# Rezoning Transportation Analysis

Petition Number: 2024-022

**From:** Jake Carpenter, PE

Date	Description
3-27-24	First Review (IW)

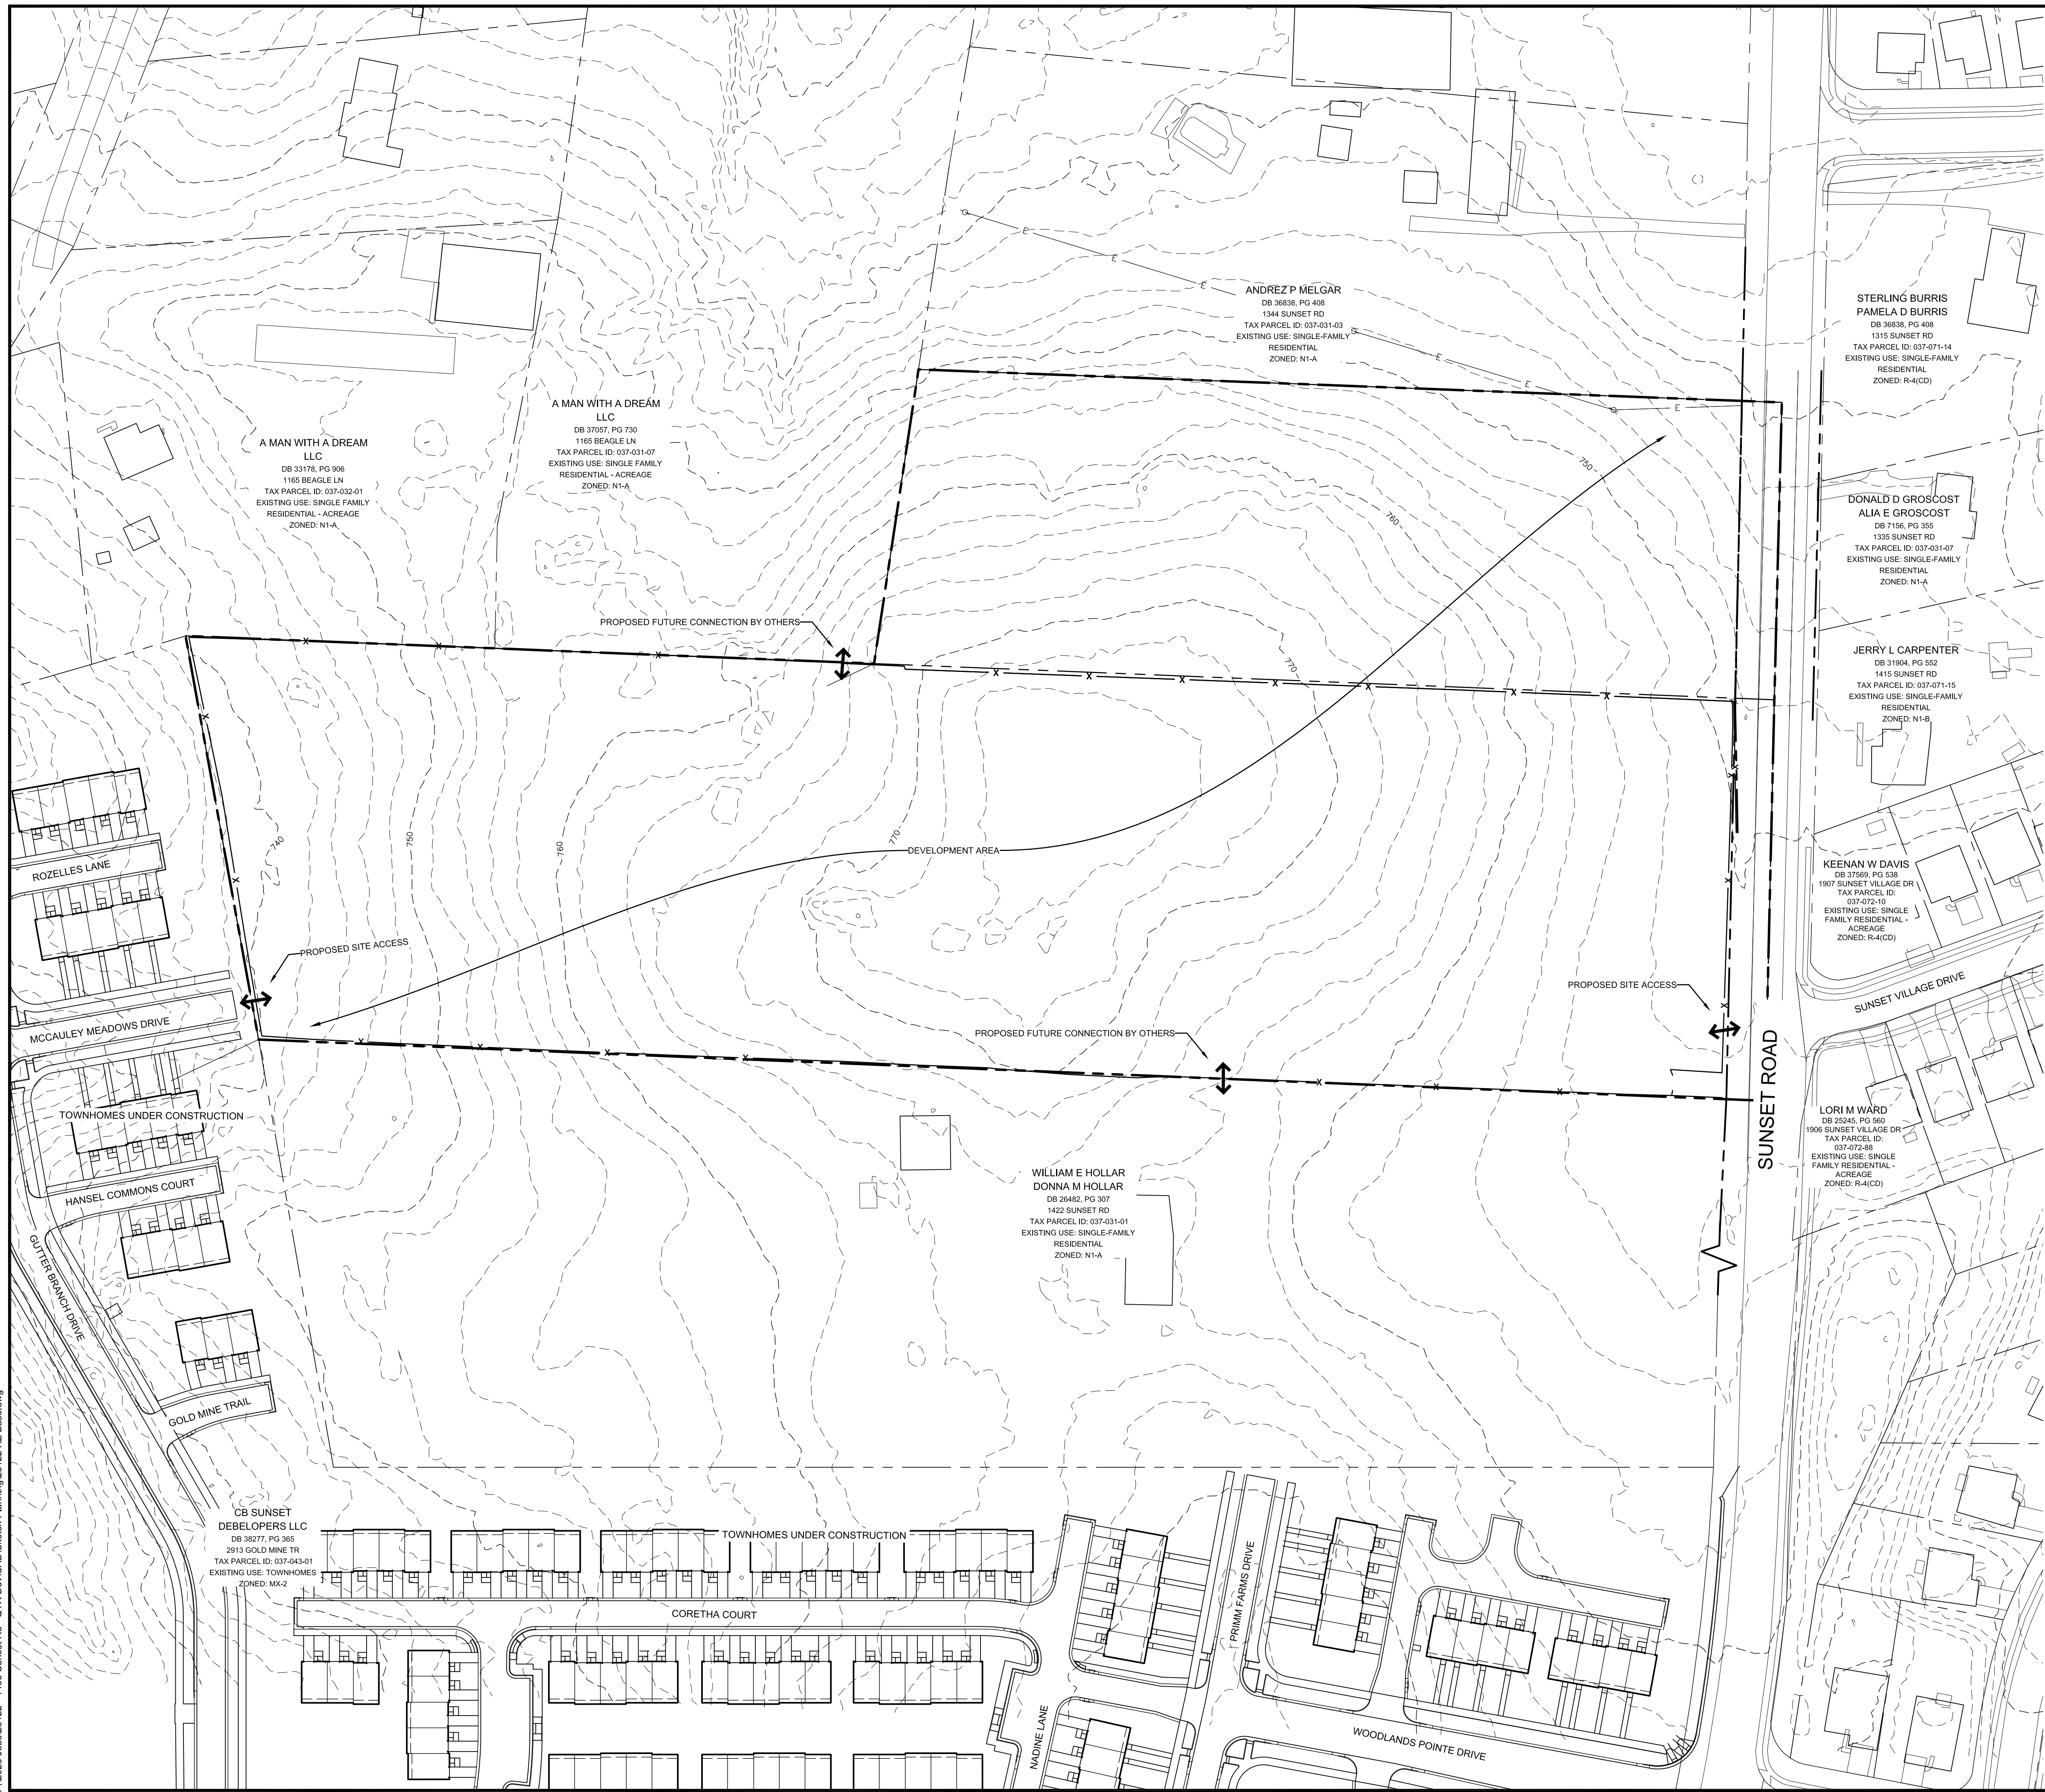
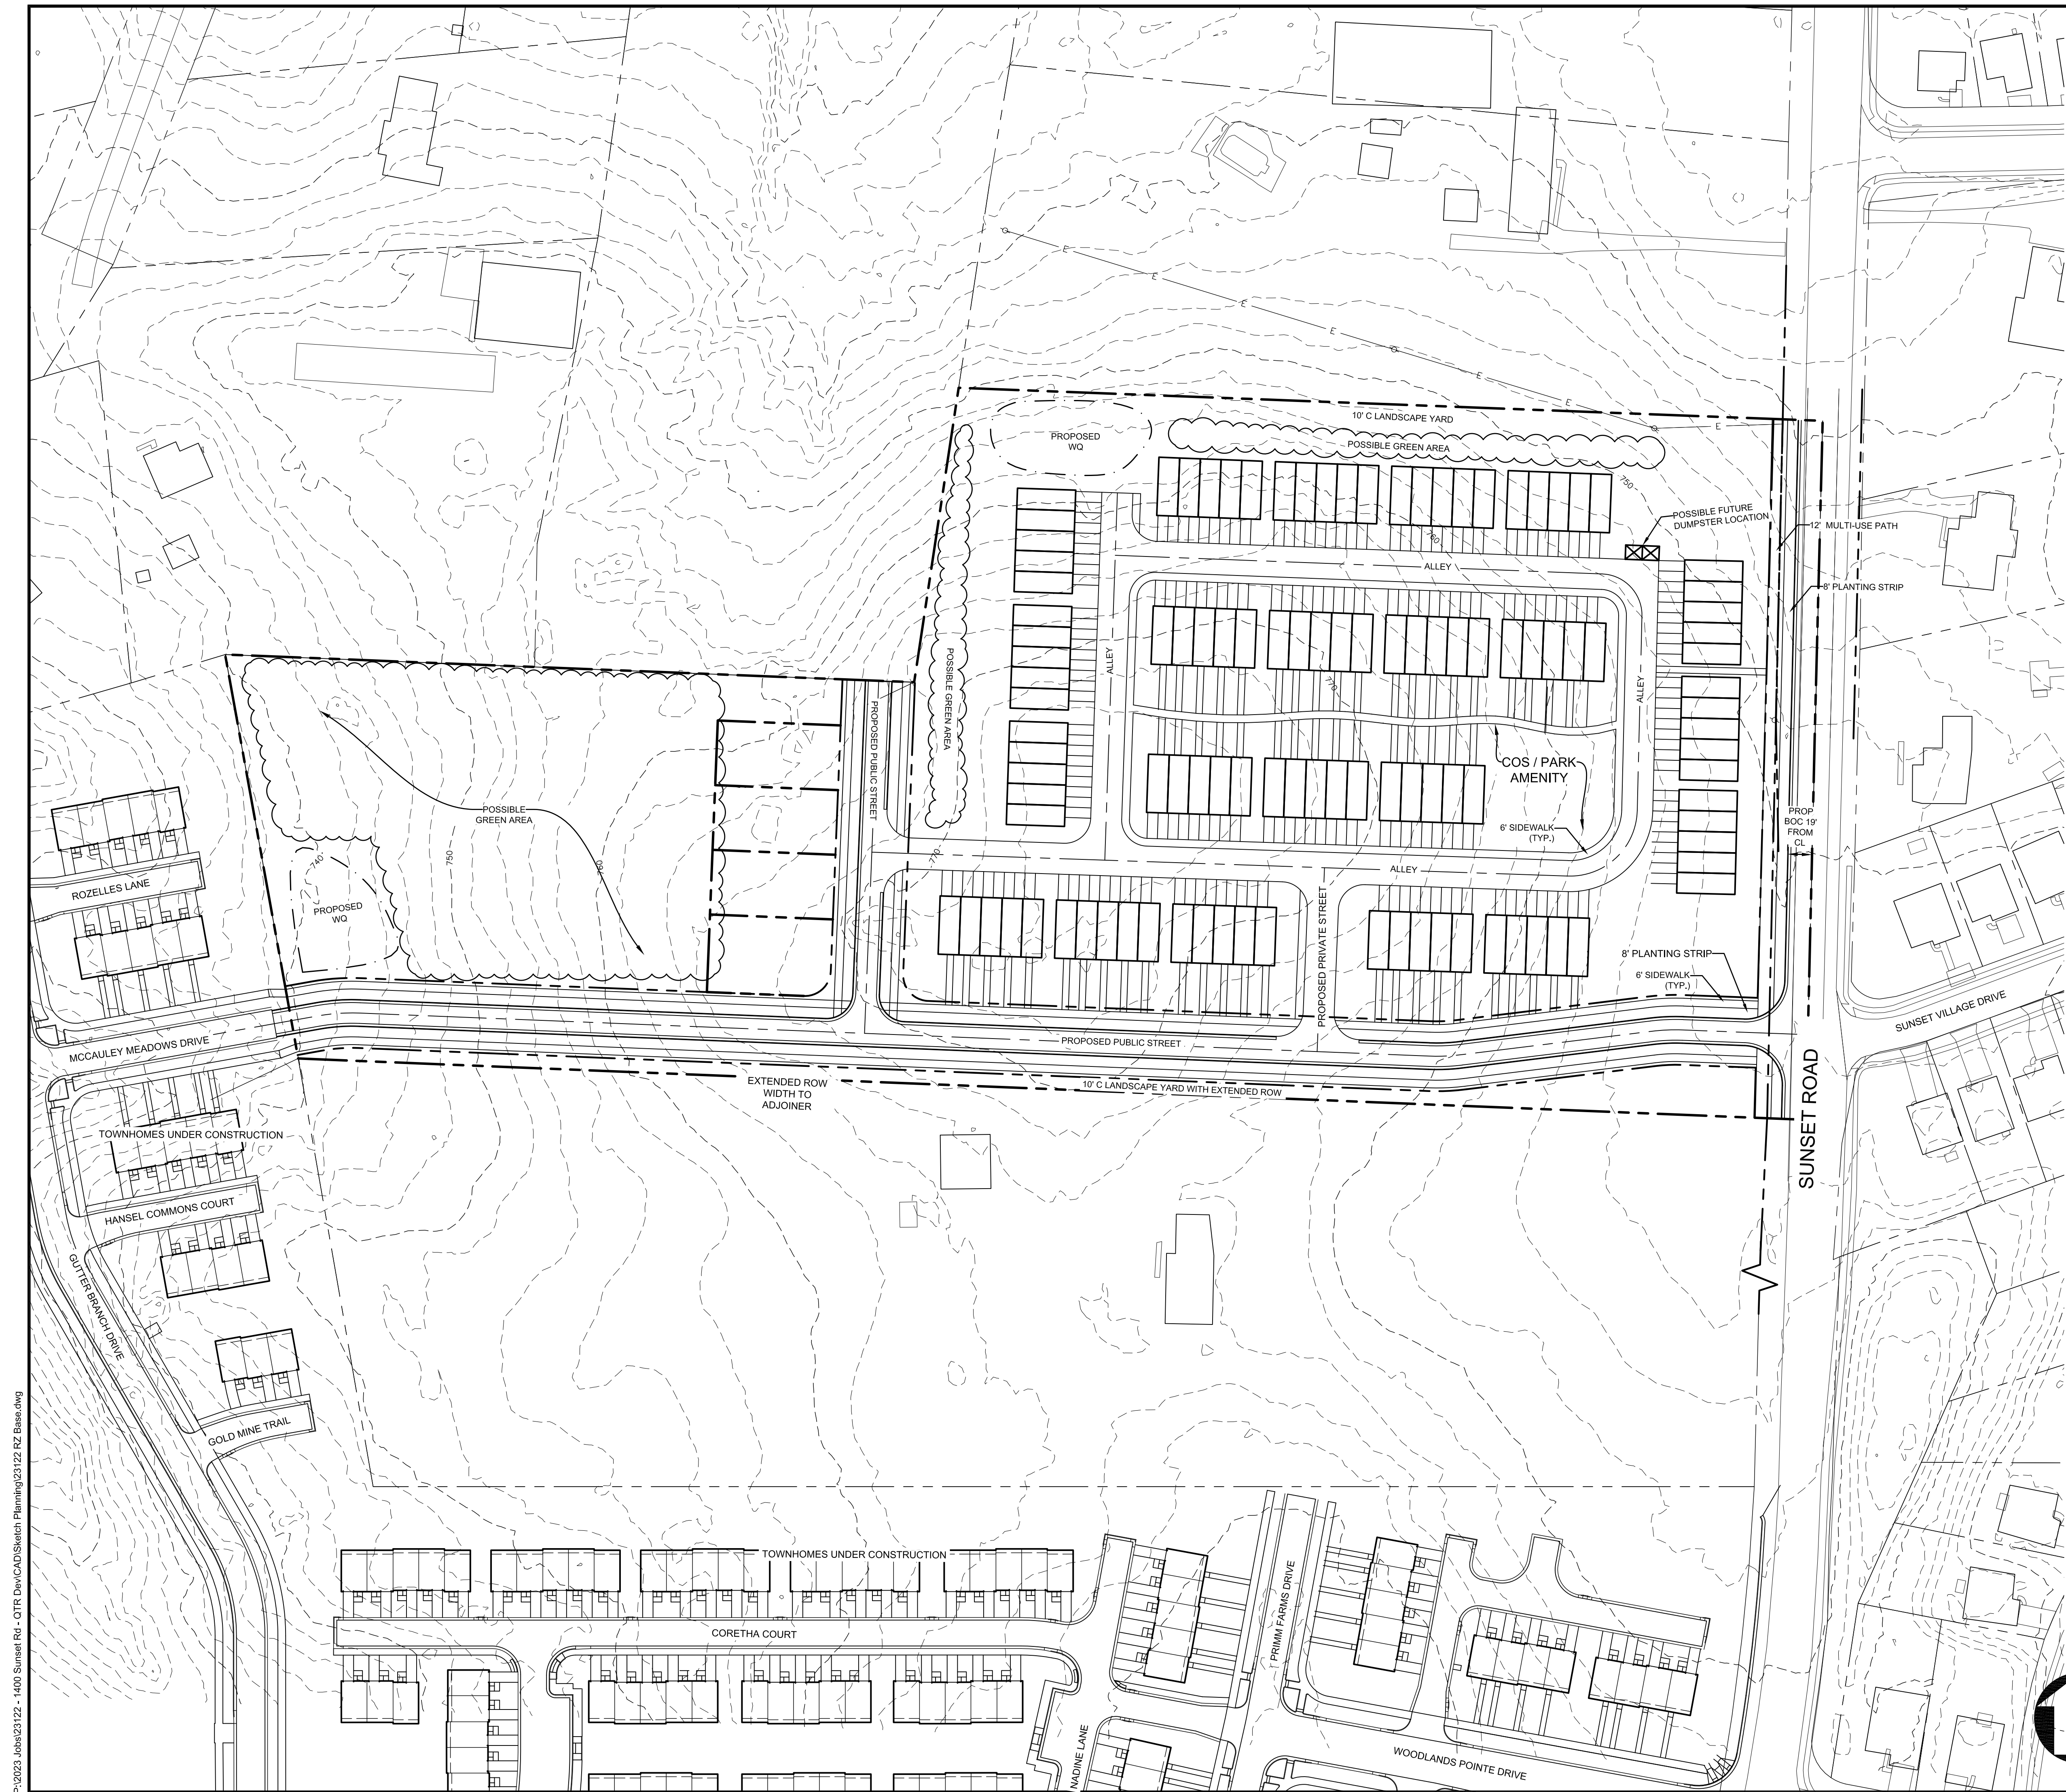
- a. **Sunset Road:** Location of future back of curb and gutter to be moved 19' from centerline.

2+ Avenue, Shared Use Path per Charlotte Streets Map

Label and dimension the curb and gutter from the centerline for each road on the site plan.

The petition's zoning falls within the low intensity development which based on the 818 daily trips will trigger Tier 1 (3 mitigation points) for multimodal assessment. The petitioner shall review and assess the publicly accessible pedestrian network within ¼ mile walking distance of the site to identify multimodal infrastructure to meet the Tier 1 (3 mitigation points) for multimodal assessment.

See Table 3.3 Multimodal Assessment Mitigation Options in the Charlotte Streets Manual for guidance. Complete CTR summary table and include on the revised plan. CTR table link (use Site Data Table – CTR Summary tab): <https://www.charlottenc.gov/files/sharedassets/city/v/2/growth-and-development/documents/dev-center-fees/resources/udo-site-data-tables-curb-ramps-and-ctr.xlsx>

- 3. Site plan shows right of way but does not dimension. Update the site plan to label and dimension the right-of-way from the road centerline along Sunset Road.
- ~~4. Revise site plan and conditional note(s) to commit to construct bicycle facilities by installing a 12' multi-use path along Sunset Road in accordance with the council-adopted Charlotte Streets Map. Multi-use paths maintained by the City shall meet ADA/PROWAG requirements.~~
- ~~5. Add a conditional note specifying "A Right of Way Encroachment Agreement is required for the installation of any non-standard item(s) (irrigation systems, decorative concrete pavement, brick pavers, etc.) within a proposed/existing City maintained street right of way by a private individual,~~

6. Revise site plan and conditional note(s) to commit to creating cross-access with the Northern Parcel fronting Sunset Road per Article 31.2 in the UDO.
7. Revise site plan and conditional note(s) to commit to creating a stub to the southern property line for future connectivity.

8. NCDOT REQUIREMENT: Revise site plan and conditional note(s) to commit to creating a left turn lane with 150 feet of storage on Sunset Road.
9. ~~Add a conditional note specifying "the Petitioner shall dedicate and convey in fee simple all rights-of-way to the City before the site's first building certificate of occupancy is issued. CDOT requests rights-of-way set at 2' behind back of sidewalk where feasible."~~
10. Add a conditional note specifying "All transportation improvements will be approved and constructed before the site's first building certificate of occupancy is issued."

Update conditional note 3.c to replace "Required roadway improvements" with "All transportation improvements" as sidewalk and other transportation infrastructure not related directly with the road will also need to be completed prior to the first CO.

of the right of way and within a public access easement. Add conditional note committing to construction and maintenance of the multi-use paths on Sunset Road.
